STATE OF WASHINGTON
DEPARTMENT OF ECOLOGY

Re: SE-18-00005

Thank you for the opportunity to comment on the Mitigated Determination of Nonsignificance SE-18-00005. We have reviewed the environmental checklist and have the following comments.

# CRITICAL AREAS STUDY MAP

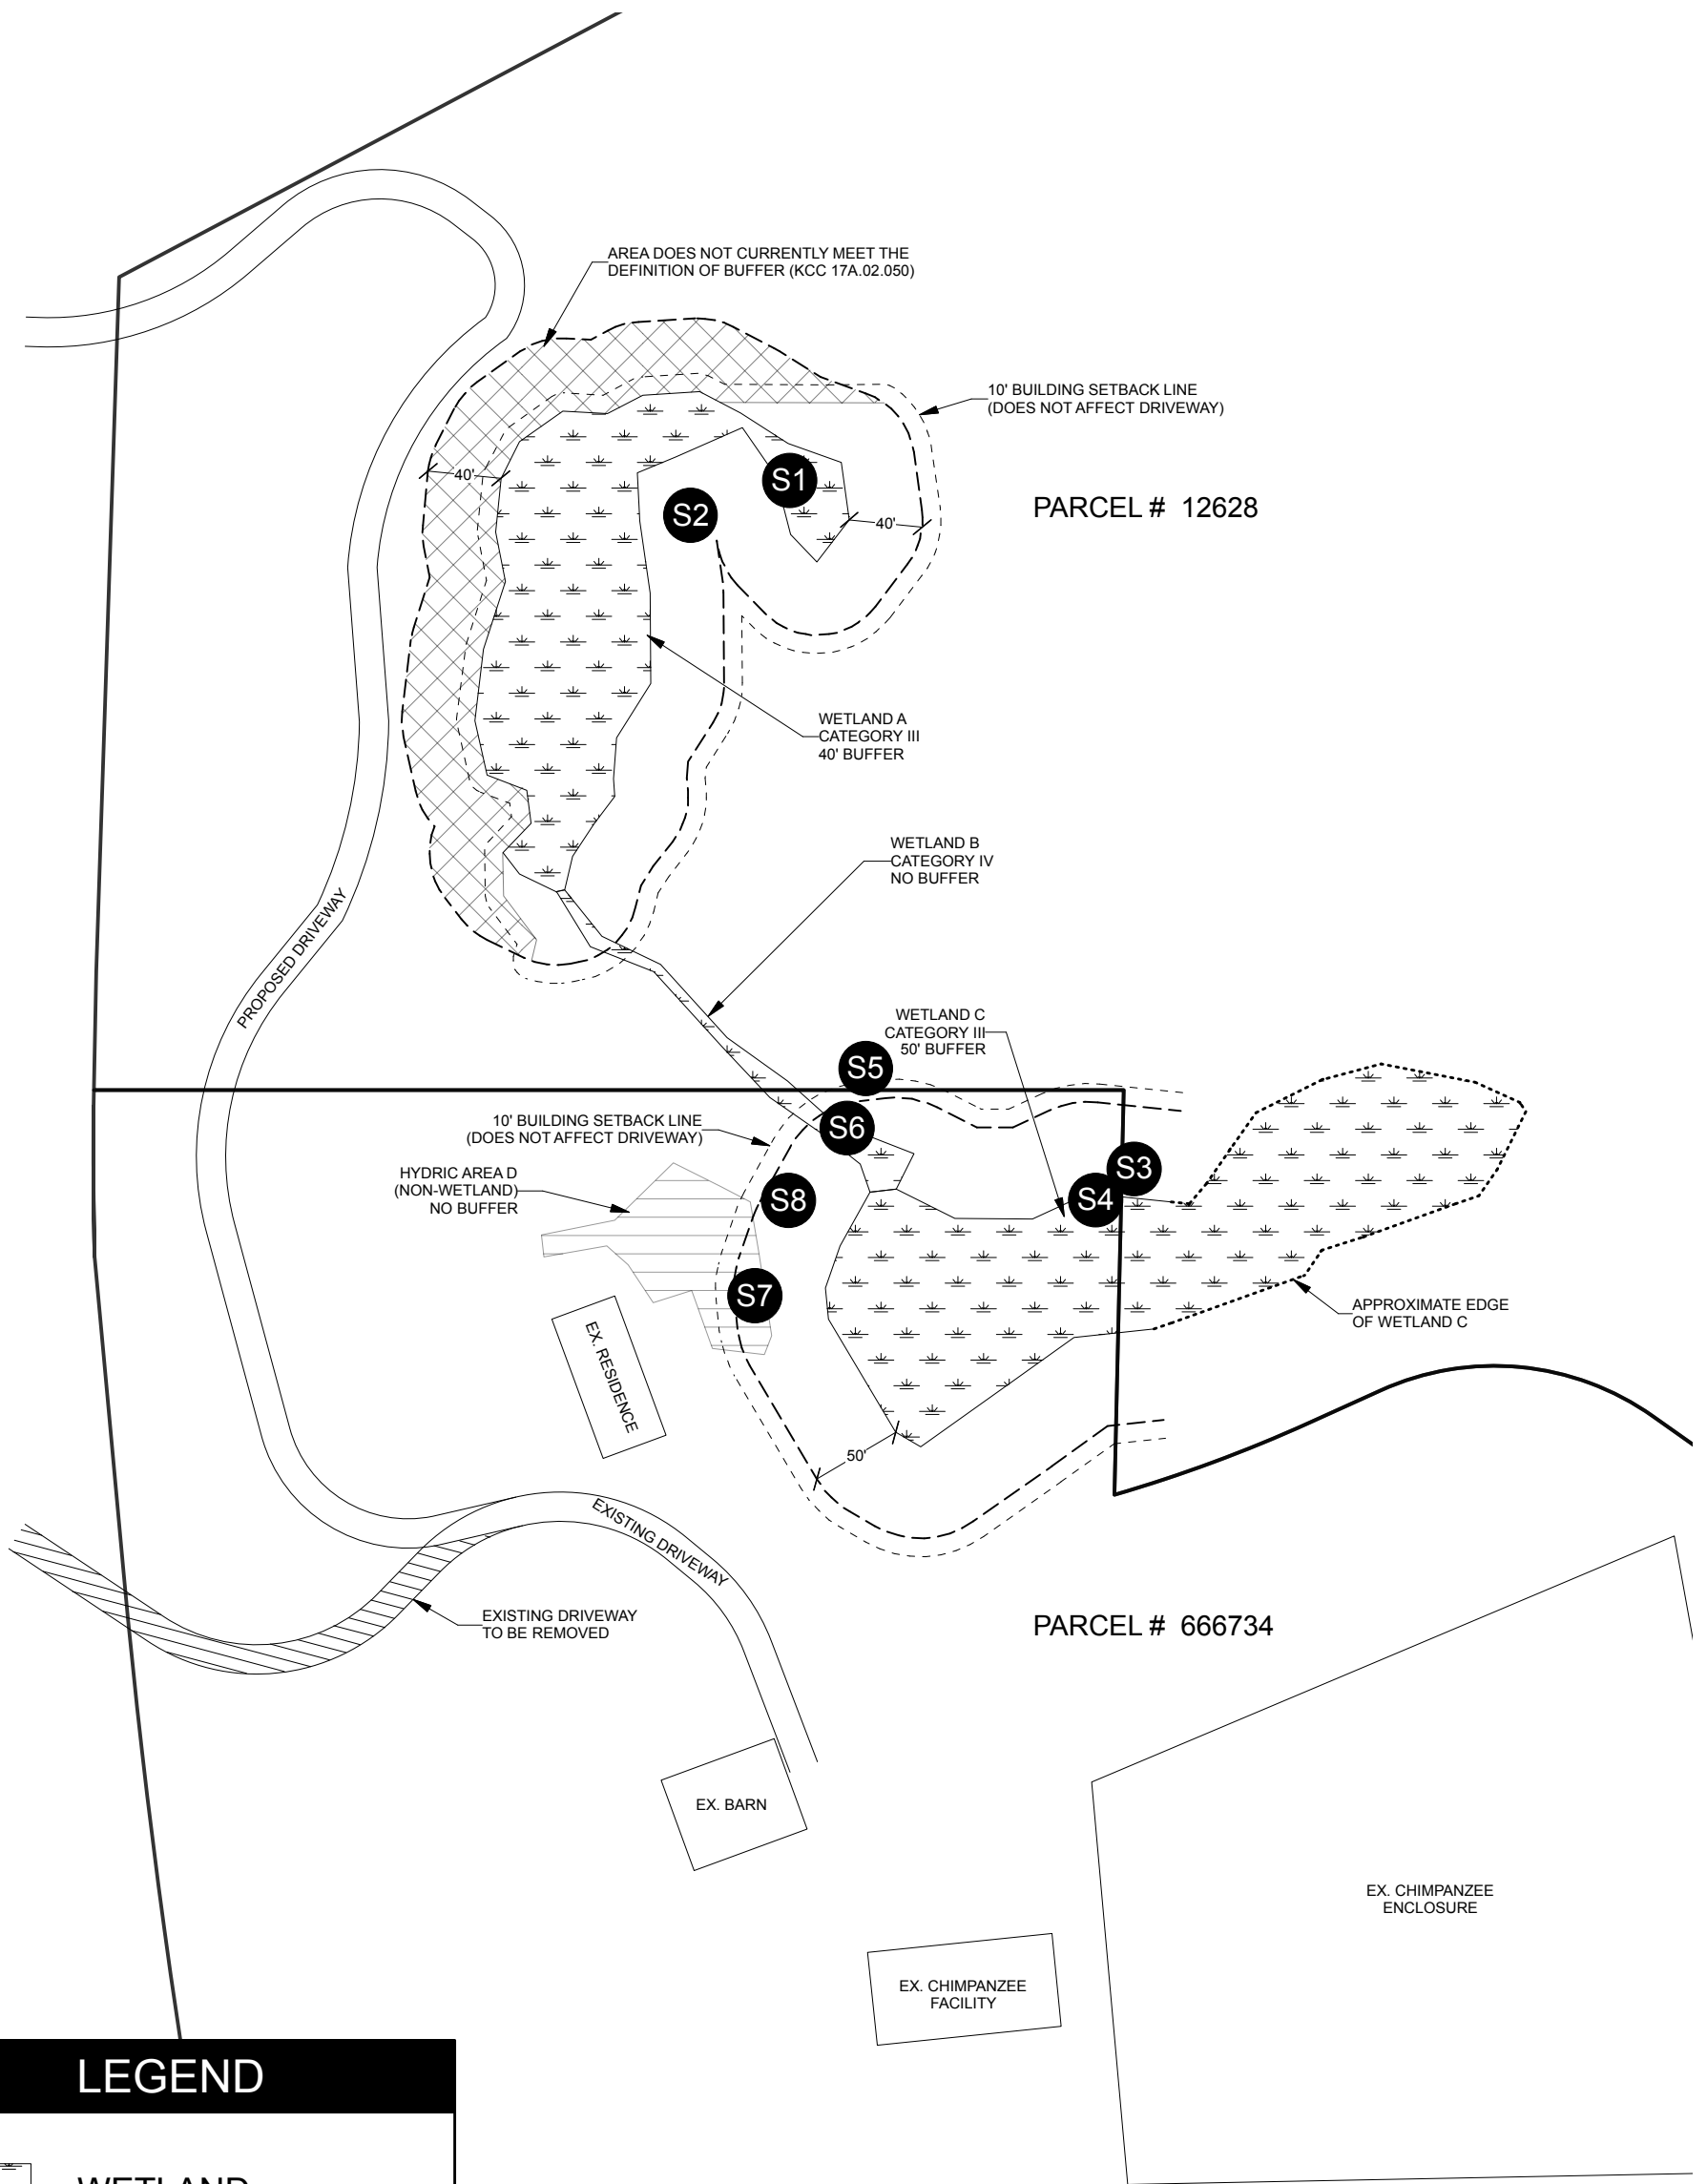
Kittitas County's Critical Areas Code, 17A.04.020, Wetland Buffers, recommends a 20 to 80 ft. wide vegetated buffer surrounding Category III wetlands. The Department of Ecology recommends the County request an 80' wide buffer surrounding each of the Category 3 wetlands. Ecology's recommendation is based on Best Available Science (BSA), our interagency guidance documents, the Habitat score of the previously reviewed wetland ratings, existing landuse intensity, the location of the site, and use of corridors in the area.

Ecology would require a 110' wide buffer for Category 3 wetlands that have a moderate Habitat score and a moderate intensity landuse. The existing landuse is considered either a moderate or high landuse intensity, due to the keeping of animals and regular maintenance. Ecology's buffer guidance documents assume the existing buffer is vegetated. The area surrounding Wetland A appears to be highly disturbed and lacks vegetation. The buffer width should be vegetated prior to the installation of the driveway. Without a planted buffer the driveway should be located even further away from the wetland. Planting the buffer will reduce noise, dust and other pollutants from entering the wetland, and provide structure adjacent to the wetland. The driveway should be located a minimum of 80' landward of the wetland boundary with at least 40' of it vegetated.
